**ADC Planning Consultation
Conservation/Design Officer Response**

Application Number	F/29/17/PL
Address	Waterbury House Ford Road Ford BN18 0BH
Description	Construction of 5 No. 1 bedroom flats (C2 Residential Institutions) together with ancillary accommodation. This application affects the setting of a Listed Building & is a Departure from the Development Plan.
Case Officer	Mrs A Gardner
Date	28 th November 2017

Drawing Title
Proposed Elevations

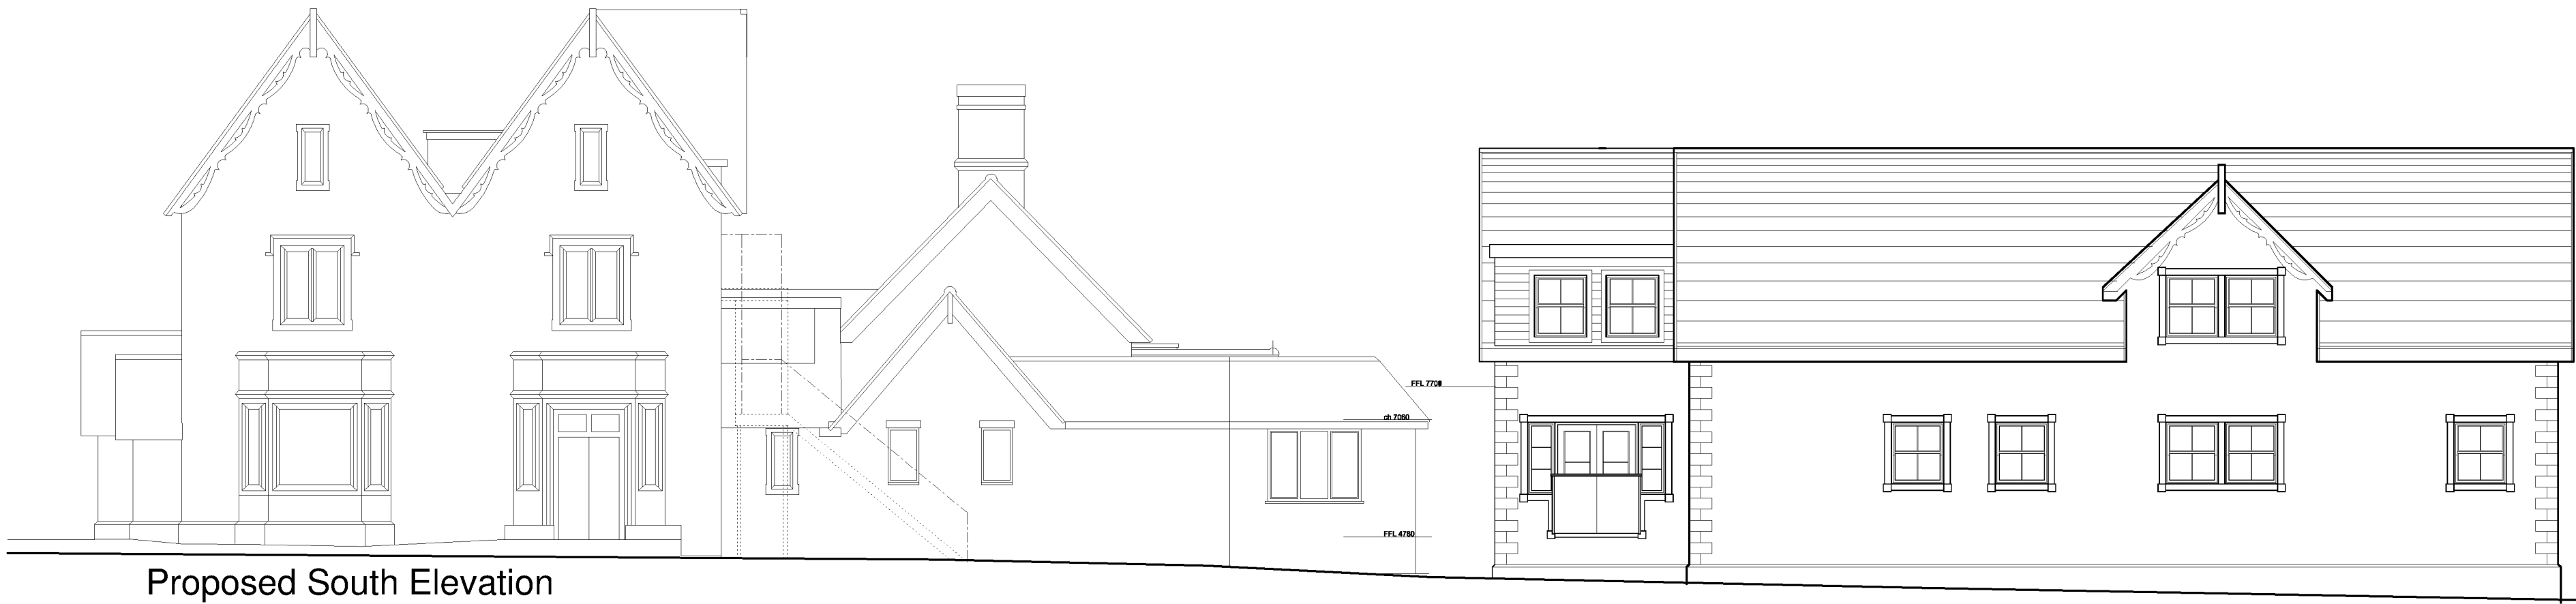
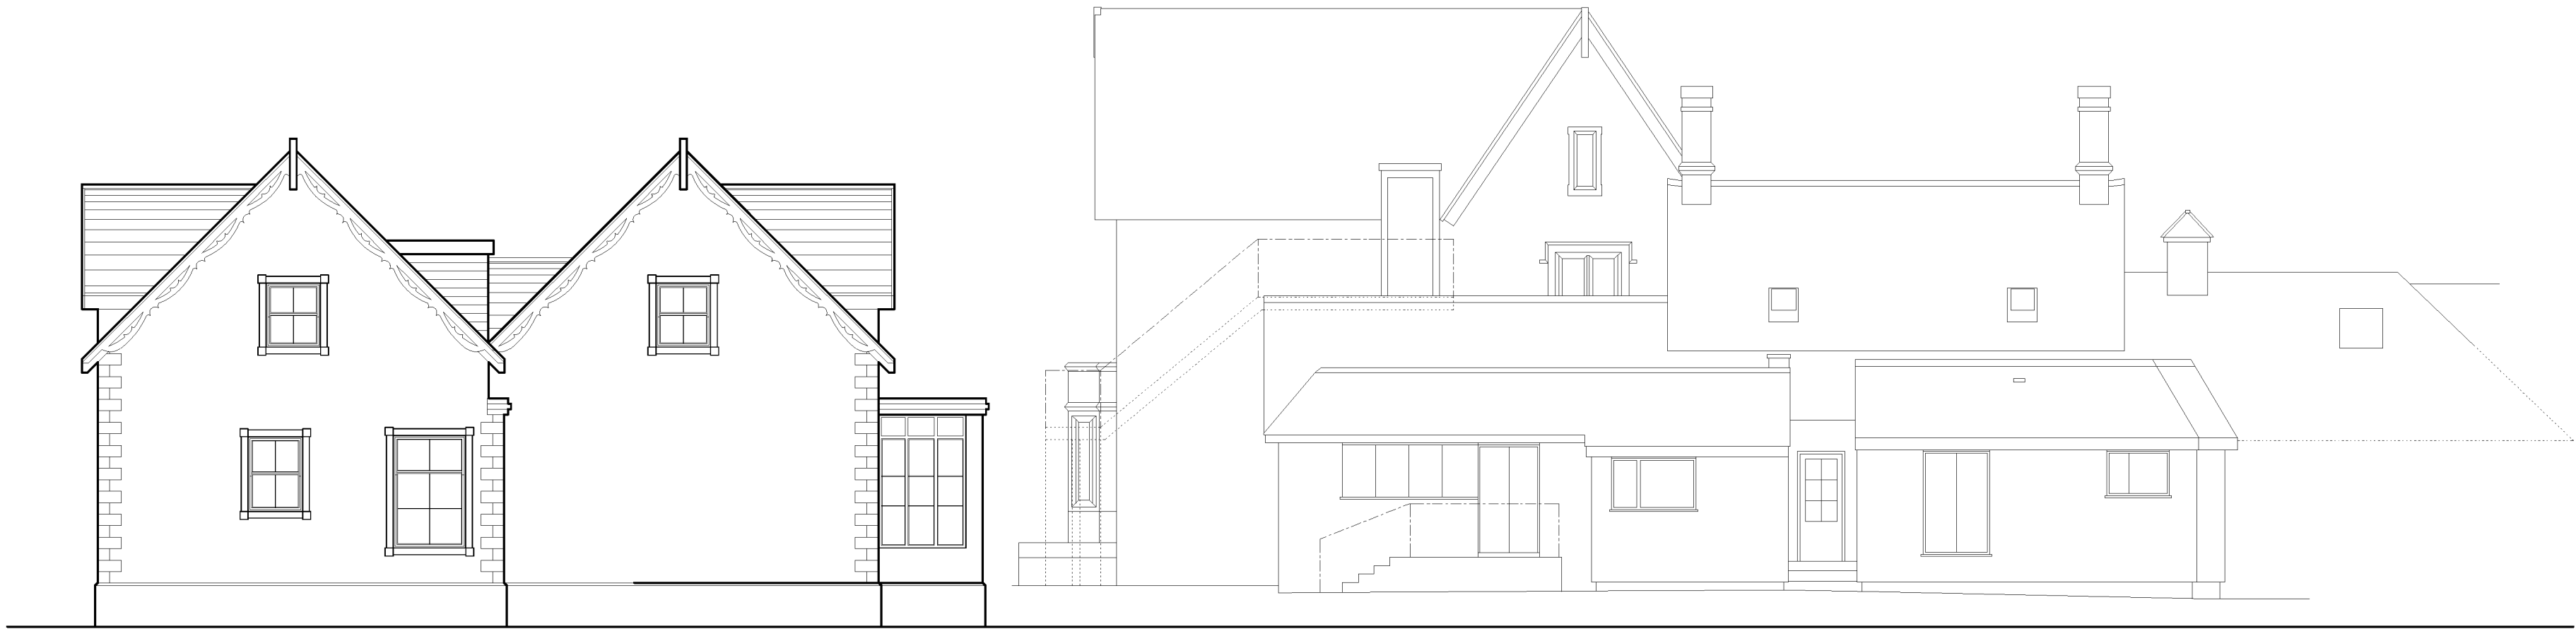
The proposal is 1.5 storey, with a bulky roofscape, comprising multiple dormer windows, with a max ridge height of 16,000mm approx. The material palette as described of brick, tile and painted wood joinery details could be in principle acceptable, subject to detail, although there are large areas of glazed guarding visible to the west and South Elevations.

It is considered that the overall mass of the building as a whole, the dominant roofscape and the proximity of the proposed development would adversely affect the setting of the listed building.
